Office of
Environment
& Heritage

DOC16/155408
SSD 6784

Parkes Solar Farm Project (SSD 6784)

OEH Review of EIS: Parkes Solar Farm

PROPOSED INFRASTRUCTURE

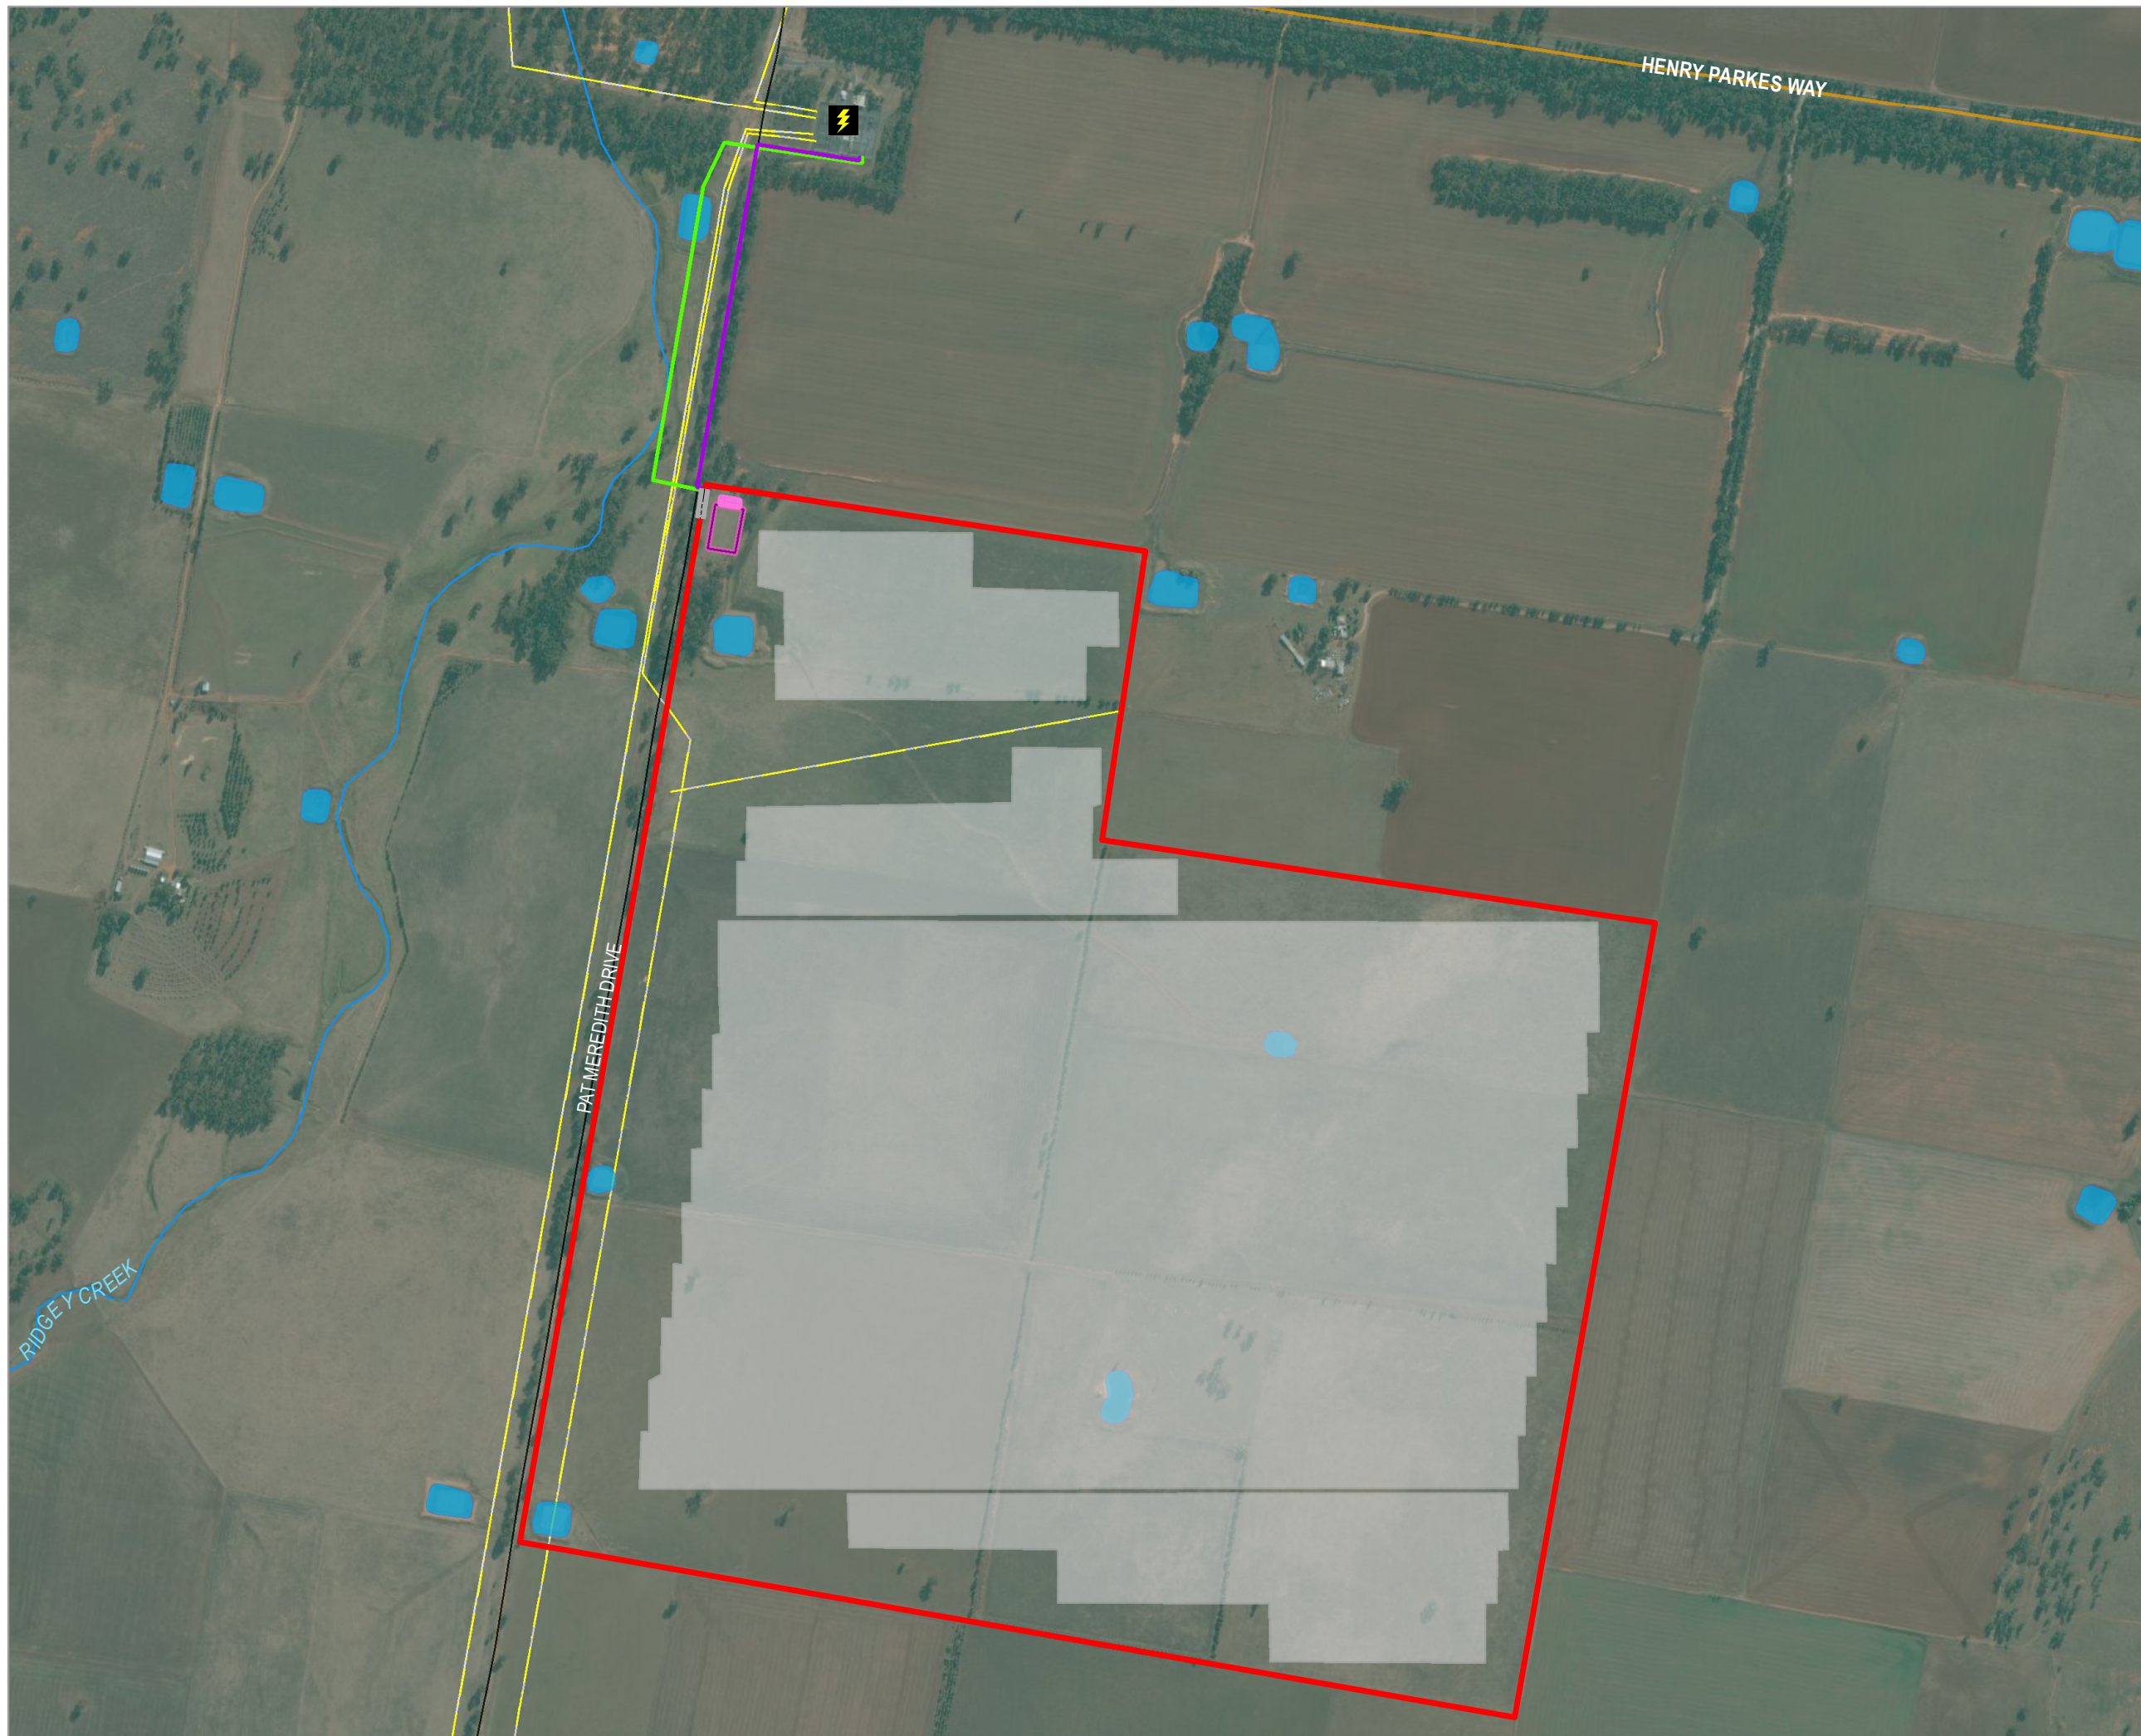
- 1.1 OEH recommends consideration of the avoidance of impacts to Grey Box EEC through alternative location and/or design of the power line connecting the solar arrays to the power station.
- 1.2 If clearing of Grey Box EEC cannot be avoided, consideration of an alternative location for the car park and site office, and enhancement of the Grey Box community in this area, is recommended.
